Our ref: DOC21/964801

Notice of Exhibition of application for Sydney Metro West – The Bays to Sydney CBD (SSI-19238057)

Annexure: Detailed commentary on the SSI proposal:

Figure 11-6 Pyrmont Station construction sites – Representative viewpoints

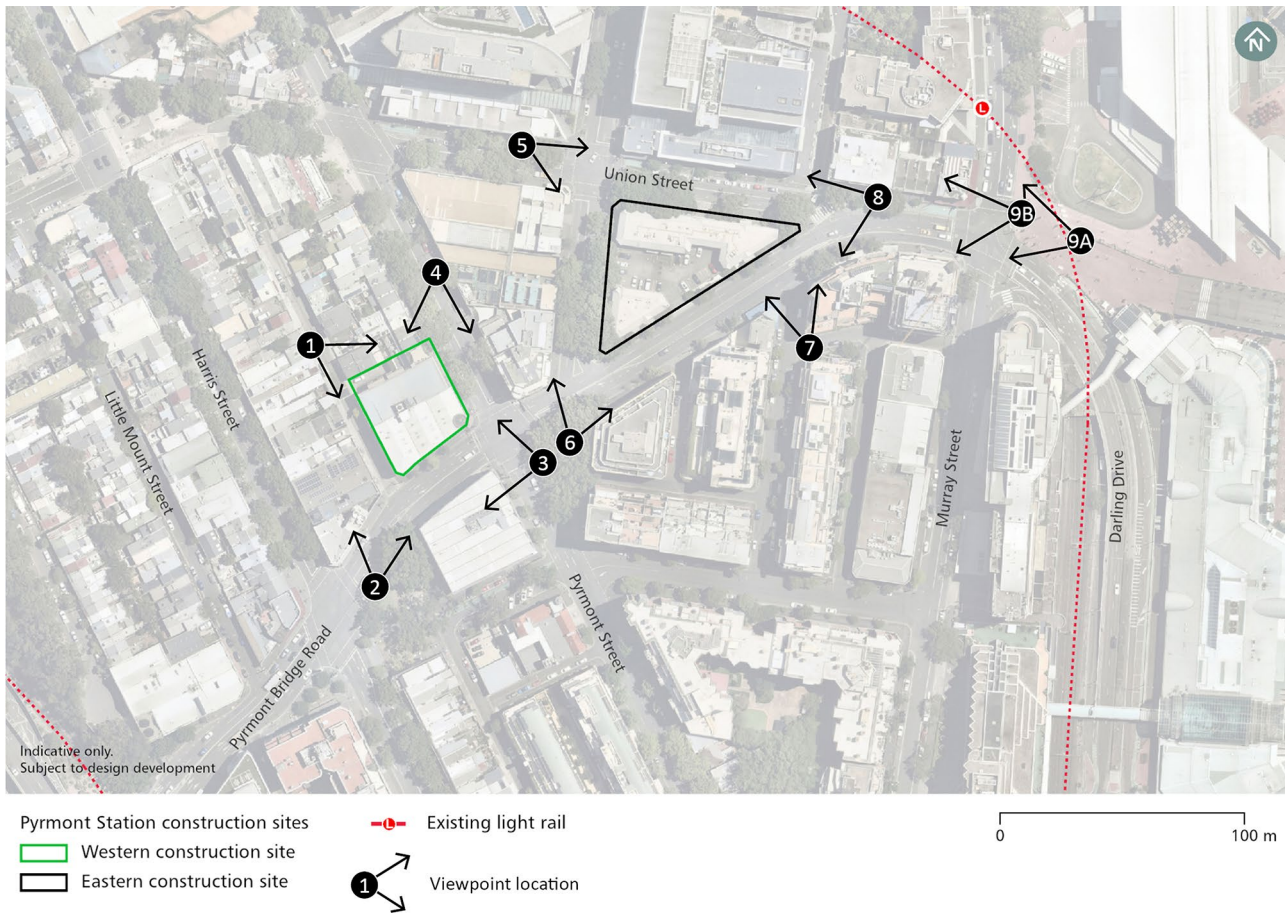
This aspect of the proposal (the acoustic shed) has not been assessed as part of Technical Paper 3, although Technical Paper 2 considers view lines from the Bridge (Tech Paper 2, Figure 6-3, p57). Technical Paper 2 identifies a “moderate adverse impact from viewpoints 8 and 9 – both of which relate to the view from Pymont Bridge. HNSW recommends that the acoustic shed designs should be carefully selected to reduce visual impacts both to the SHR

listed Pyrmont Bridge and the neighbouring streetscapes. The mitigation measures recommended in Tech Paper 2, viii may assist in reducing visual impacts to this area as well as for the eastern part of the Hunter Street Station. The Eastern Part of the Hunter Street Station has a visual impact from acoustic sheds to the Richard Johnson Square which is surrounded by three neighbouring SHR items (City Mutual Life Assurance Building; NSW Club and the Perpetual Trustee Company).

Consideration of design, materials, size/bulk (potentially with a height setback) and colour may reduce some of these impacts. The designs should be developed further with the advice of a built heritage expert in the flagged areas of heritage sensitivity. Potential options such as hoarding or interpretive signage may be additional options to reduce impacts. Retention of street trees is also supported as a buffering element to the new sheds.
